PLANNING CONSULTATION RESPONSE

Application No	2025/0153
Proposal	Demolition of existing dwelling (retrospective) and erection of 1no. detached dwelling with integral garages
Address	Hirst Cottage, Chapel Lane, Billingley, Barnsley, S72 0HZ
Date of Consultation Reply	1 st December 2025
Consultee	Highways DC

[2nd Response – Amended scheme]

Drawing Title.
**SITE & LOCATION
PLAN AS PROPOSED**

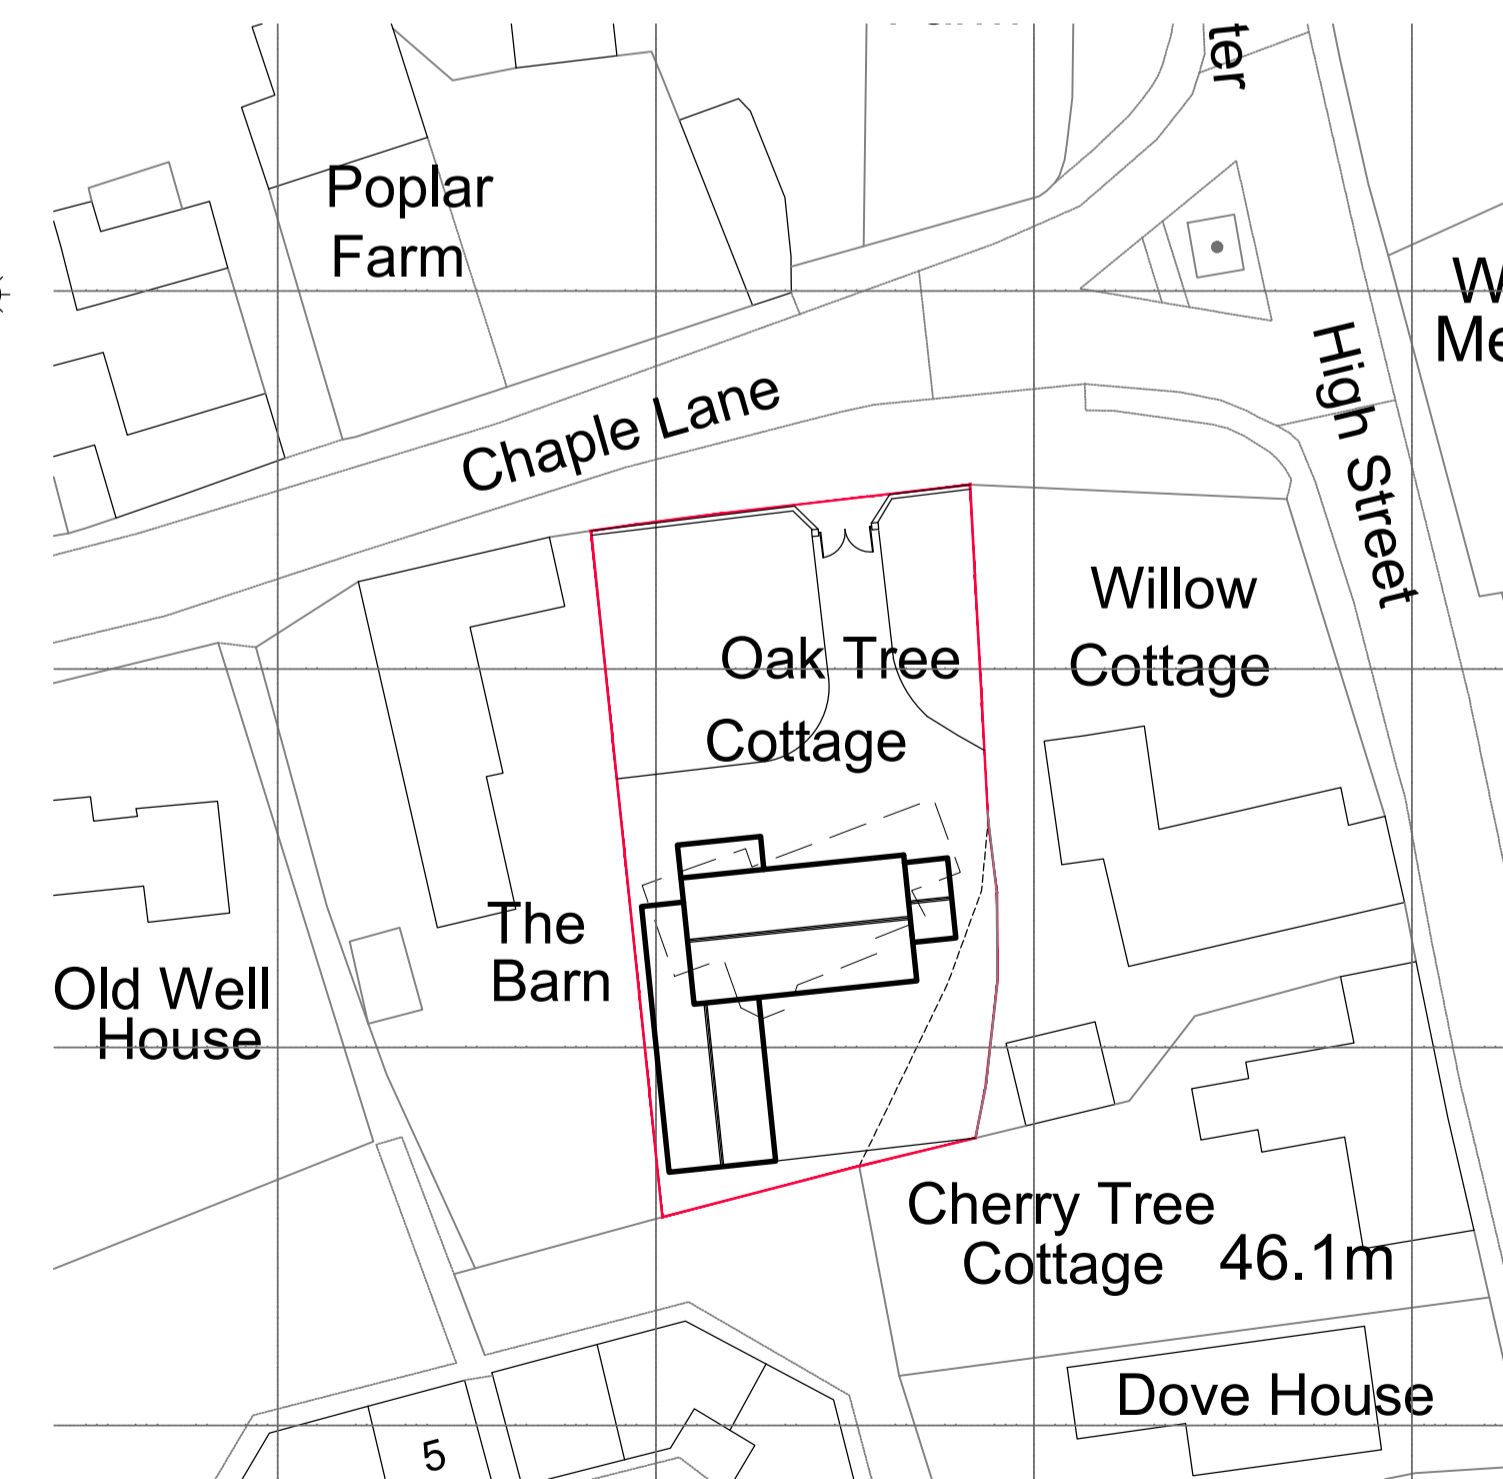
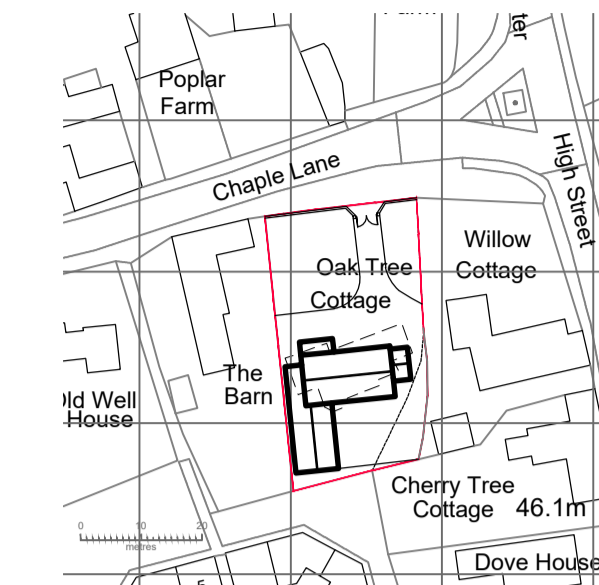
The amended proposals still include ample parking and turning provision within the site. In terms of the existing access, as per the previous proposals, no changes are proposed to either the width or position, as such, the 2m x 2m visibility splays currently achievable are not adversely affected by the proposed increase in height of the boundary wall and gates. As such, the proposals are considered acceptable from a highways development control perspective subject to the condition and informative note listed below, which I would be grateful if you could include if you are minded to grant permission.

Prior to the development being brought into use, all areas to be used by vehicles shall be laid out in accordance with the approved plan and shall be surfaced in a solid bound material (i.e. not loose chippings) and made available for the access, parking and manoeuvring of motor vehicles, and shall be retained for said purposes at all times. Adequate measures shall be so designed into the proposed vehicular areas to avoid the discharge of surface water from the site on to the highway. **Reason: To ensure that there are adequate parking facilities to serve the development which are constructed to an acceptable standard; to ensure adequate provision for the disposal of surface water and to prevent mud/debris from being deposited on the public highway and to prevent the migration of loose material on to the public highway to the detriment of road safety and in accordance with Local Plan Policy T4 New Development and Transport Safety.**
